Lime Down

Solar Park

Change Notification

Planning Inspectorate Reference: EN010168

APFP Regulation: APFP Regulation: 5(2)(a)
Application Doc no.: APP /6.2
Drawing no.: Figure 13-11

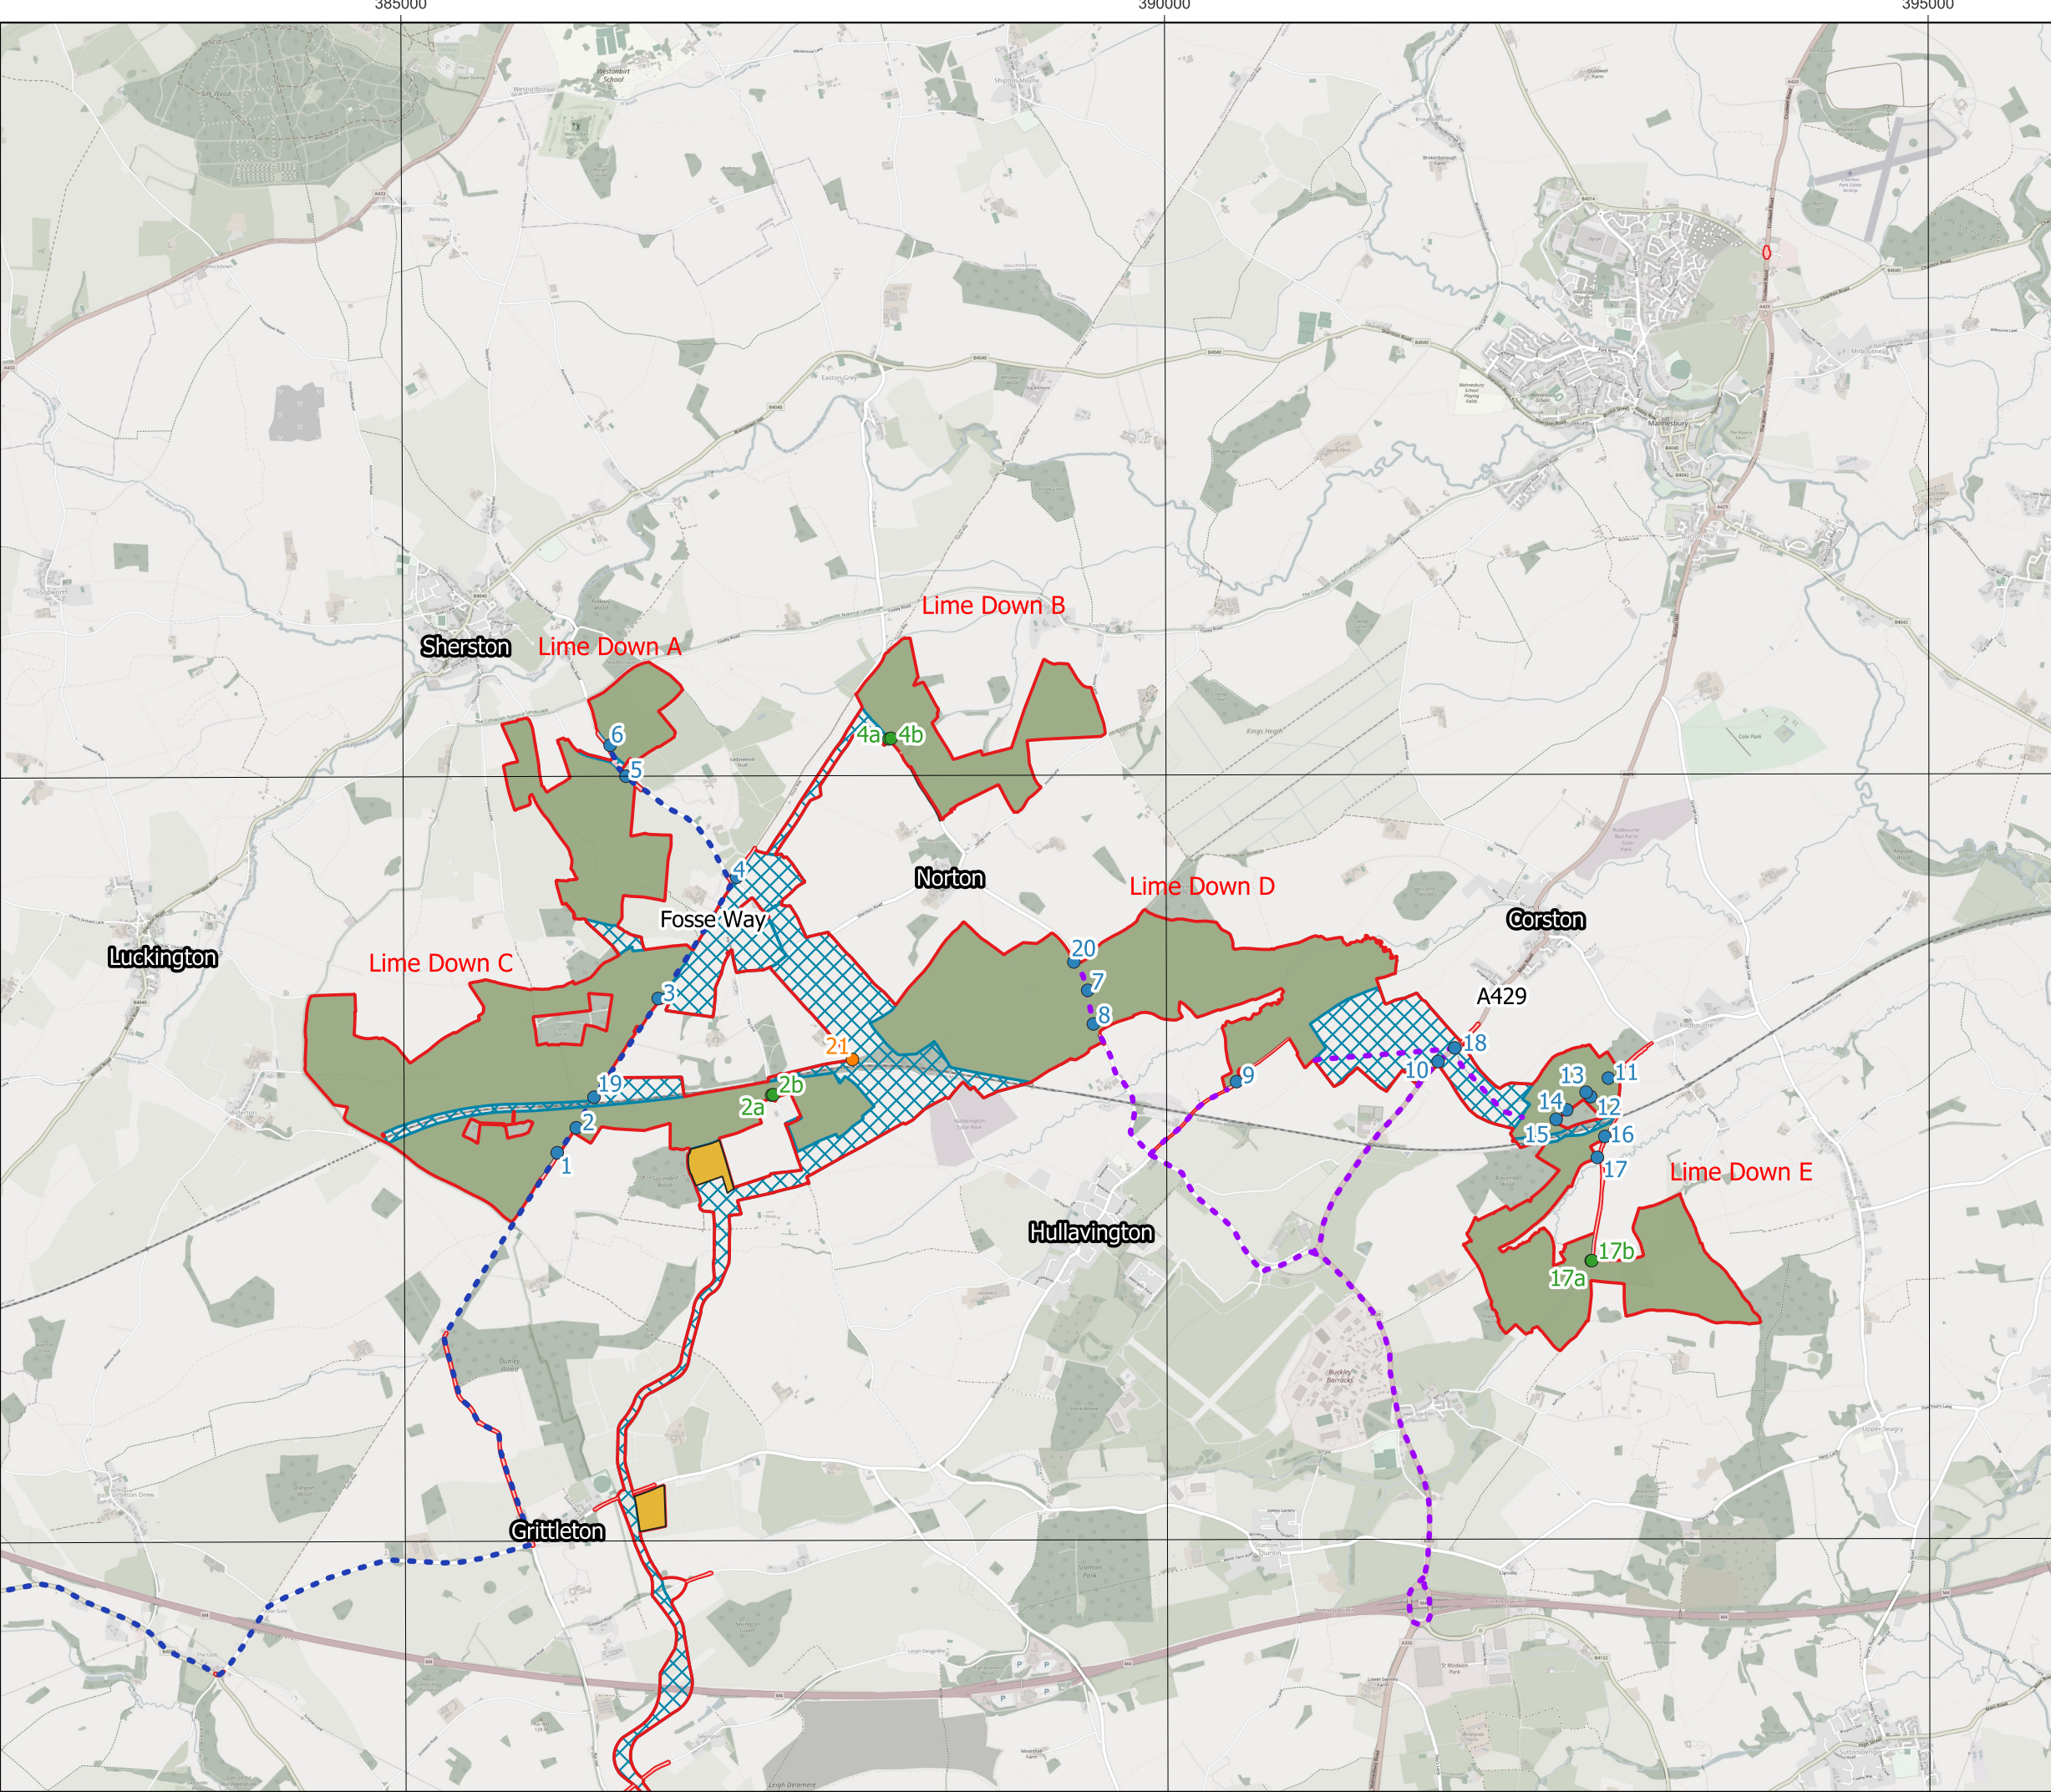
2.1.1 Change 1 comprises an extension to the Order Limits from the south western extent of the BESS emergency access (Access 21) at Lime Down D to the public highway named Hills Hayes Lane. A post-submission review by the Applicant of the Scheme accesses indicated that Access 21 did not adjoin the boundary of the public highway. This change will allow emergency Access 21 to tie into the public highway. The additional land will contain the bellmouth of emergency Access 21 which will comprise hardcore or gravel over a levelling layer of substrate.
